Traffic Impact Study

Circle K – US-24 & Meridian El Paso County, Colorado

See comments on pages
1-39 throughout

Add "PCD File No.
CS-21-003"

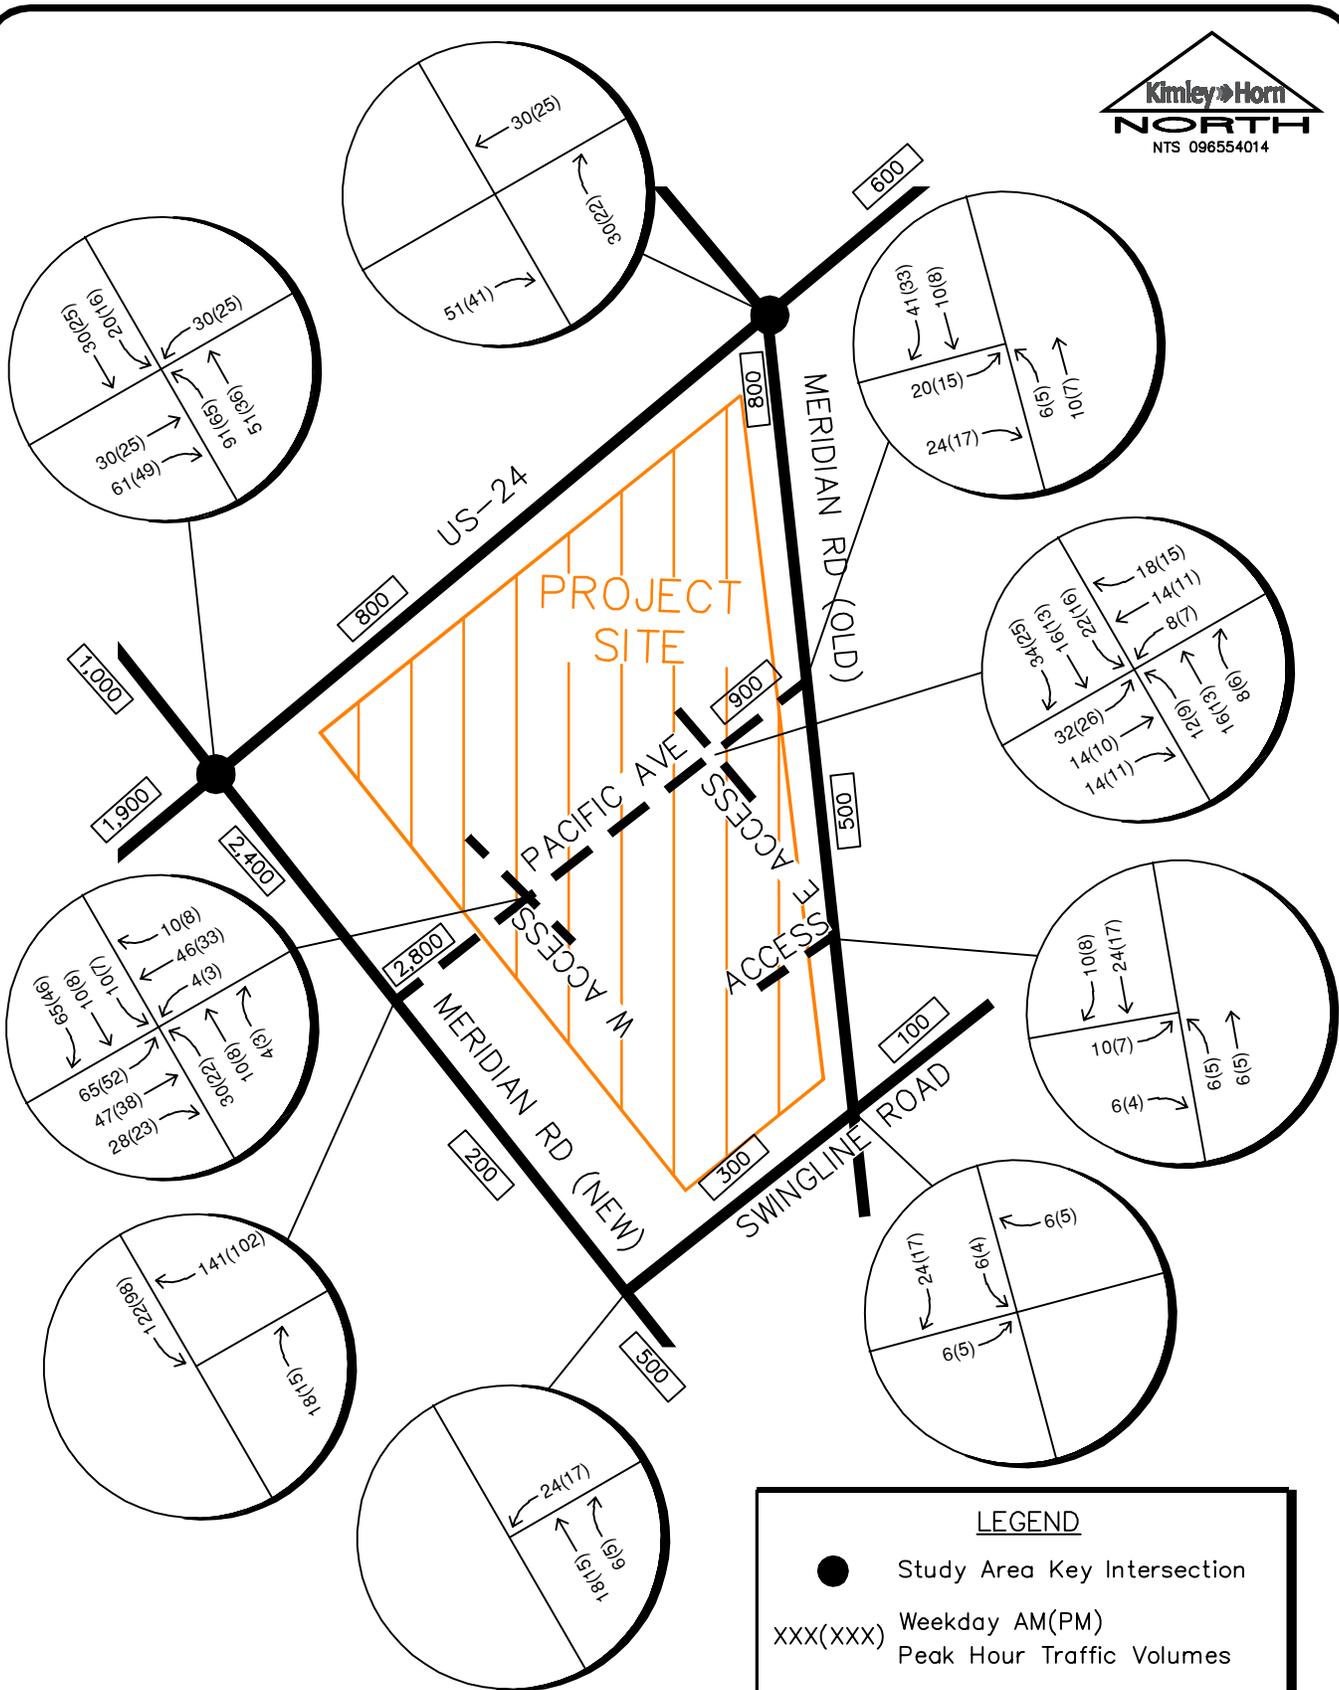
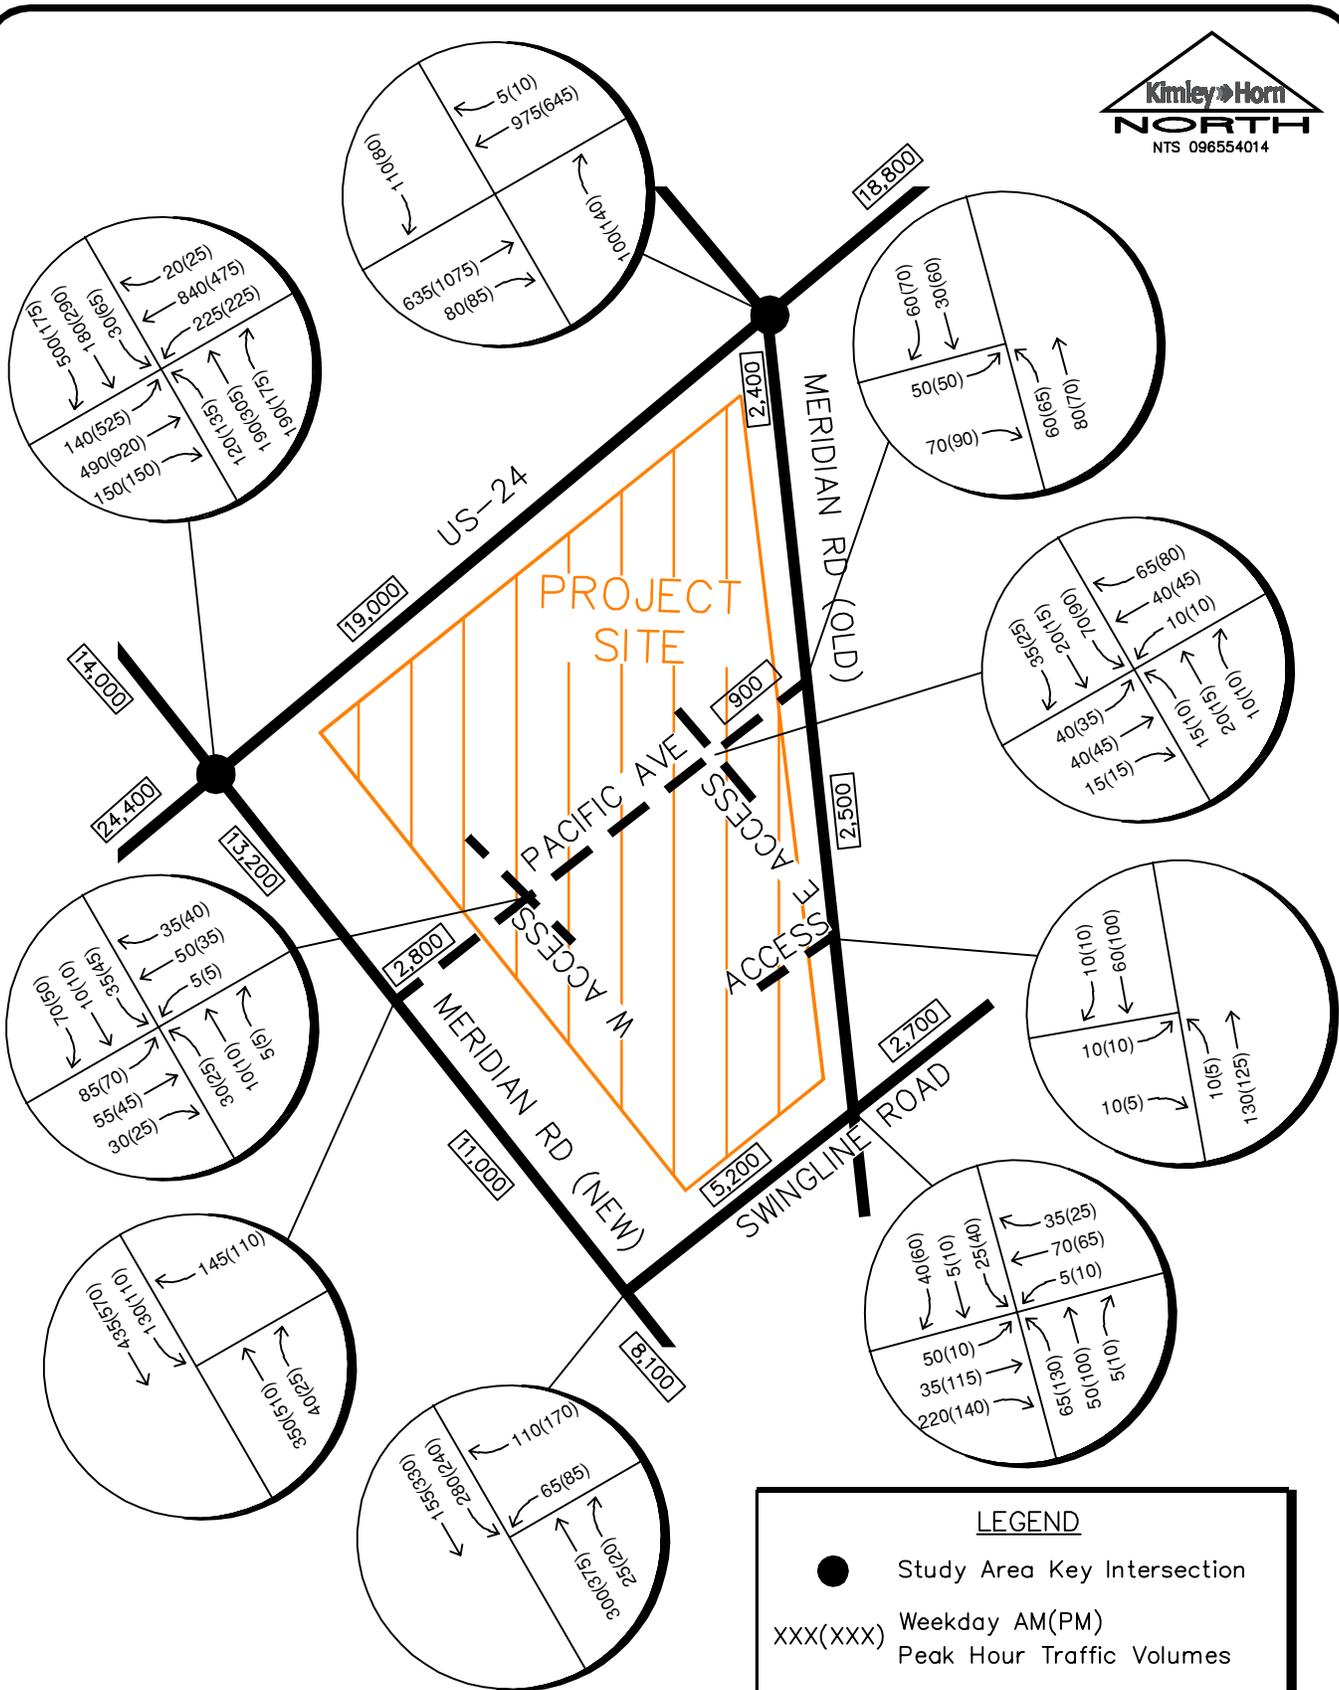
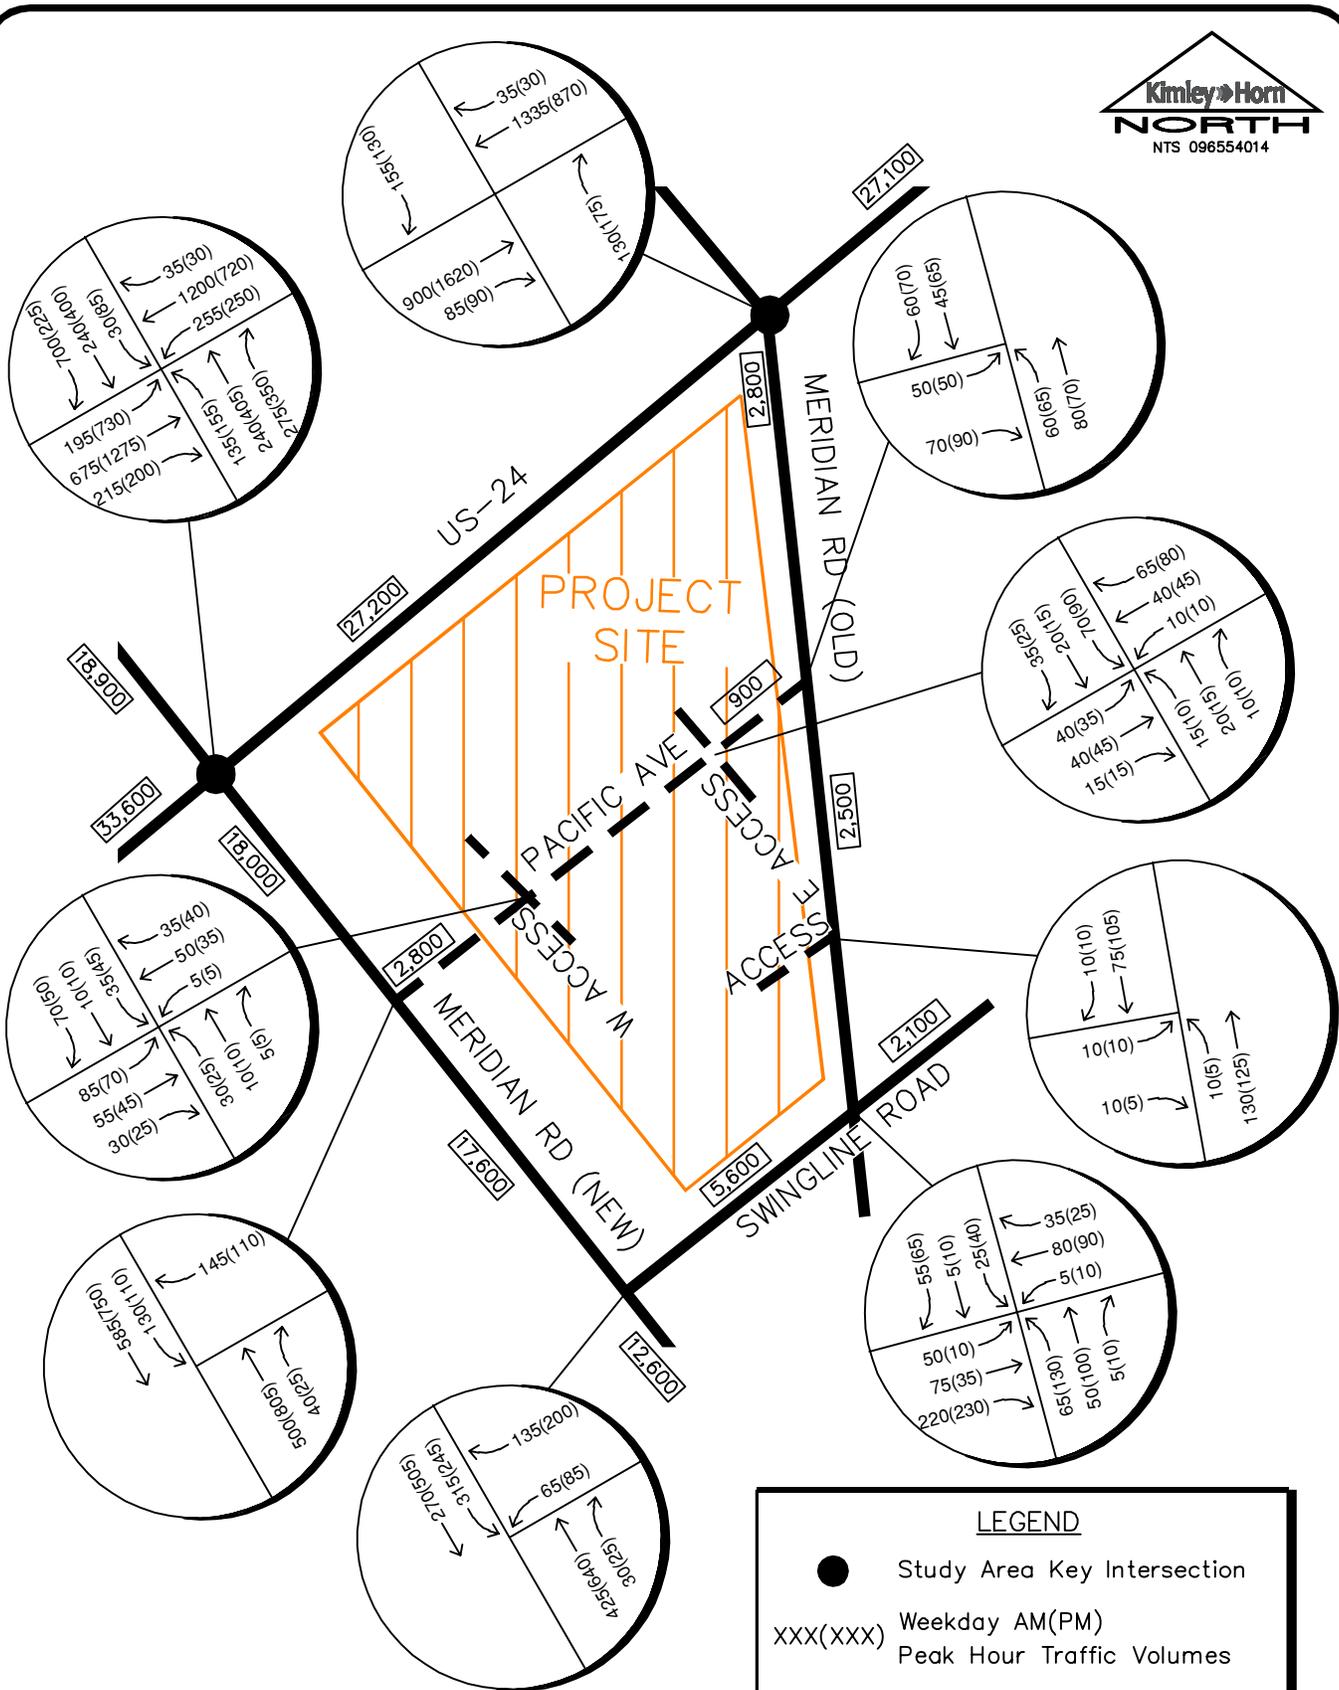
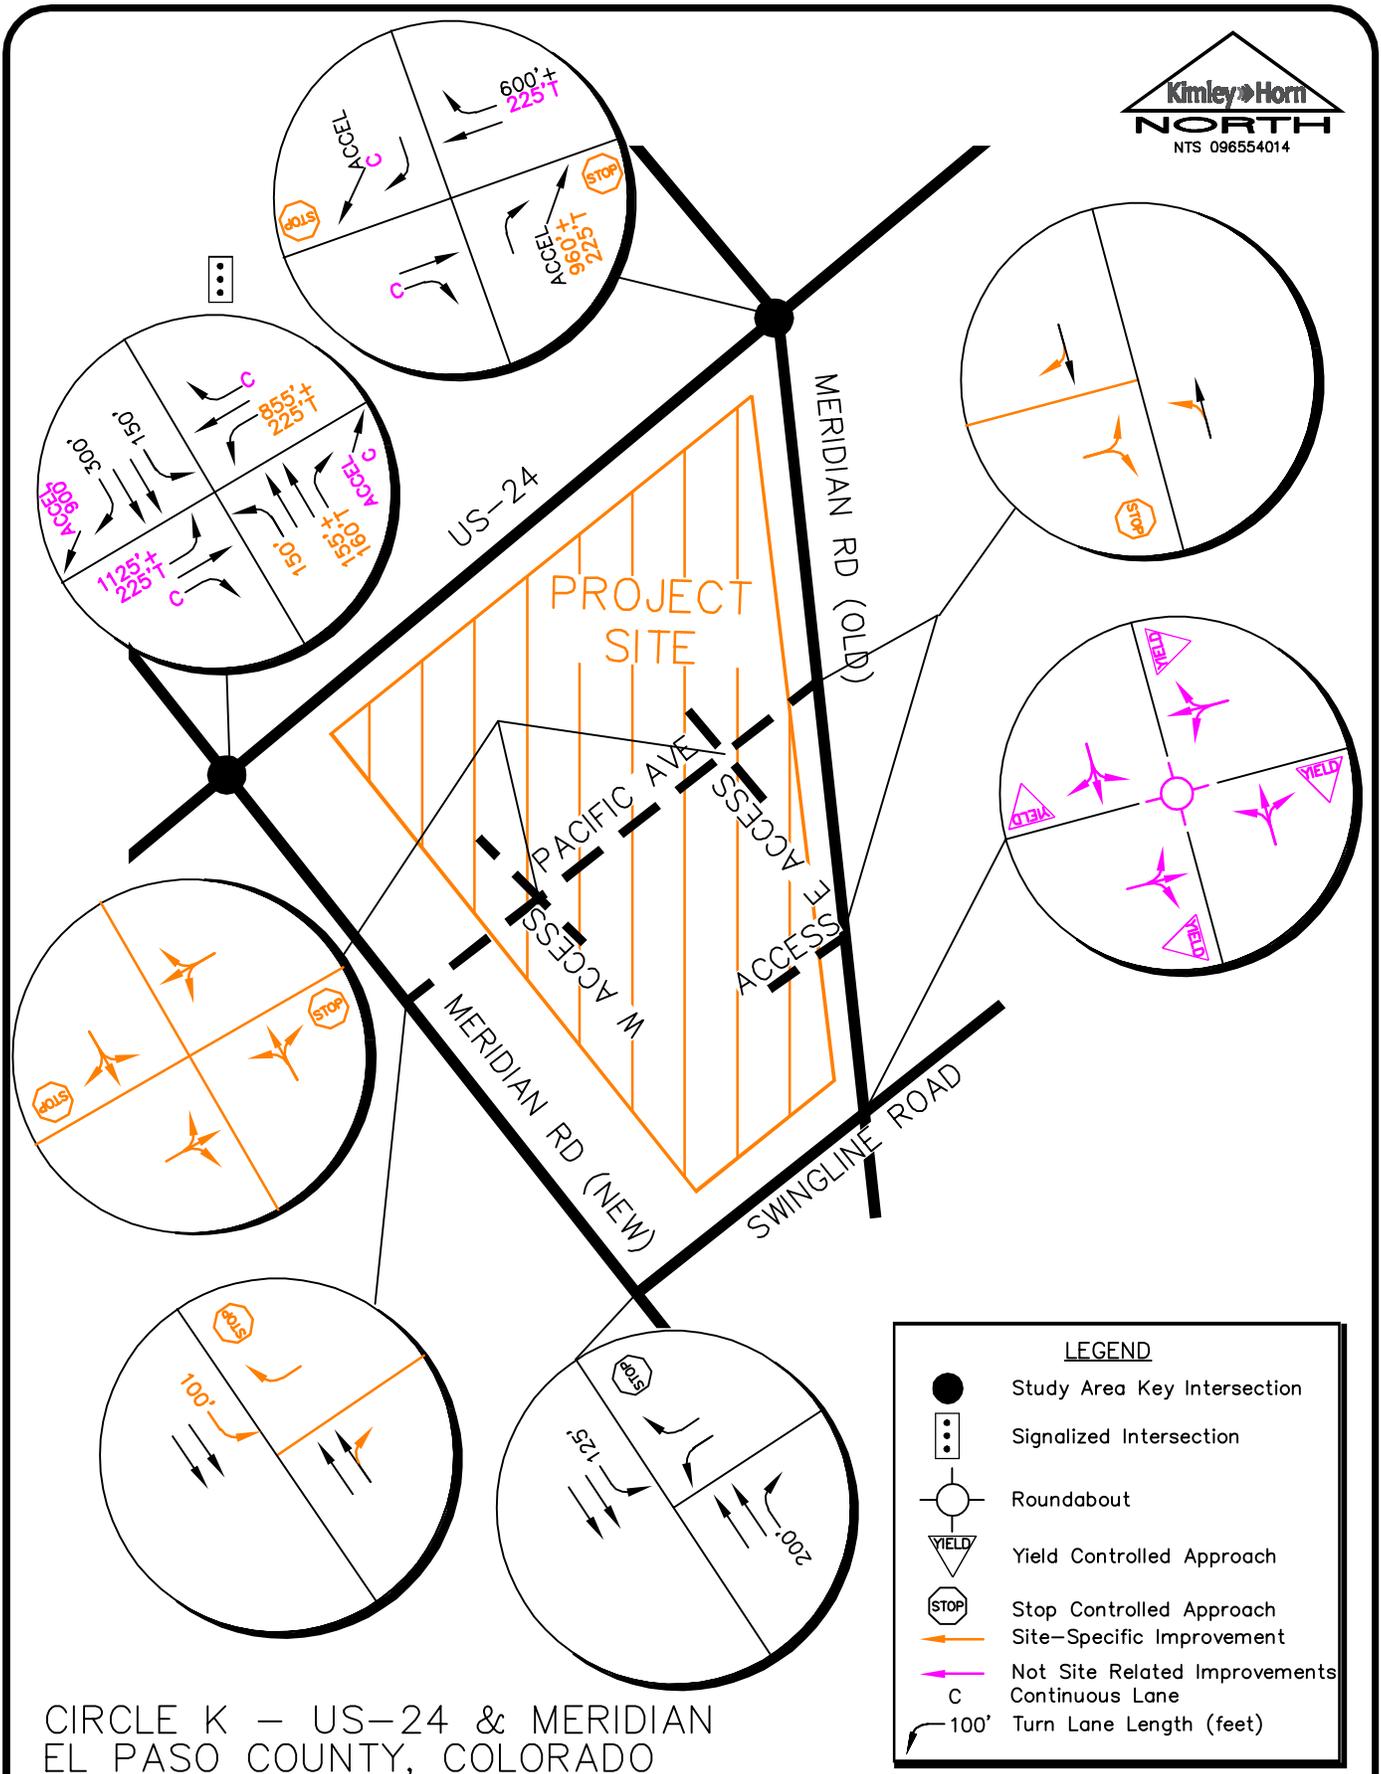
Update project site
 FIG 8-13 onward
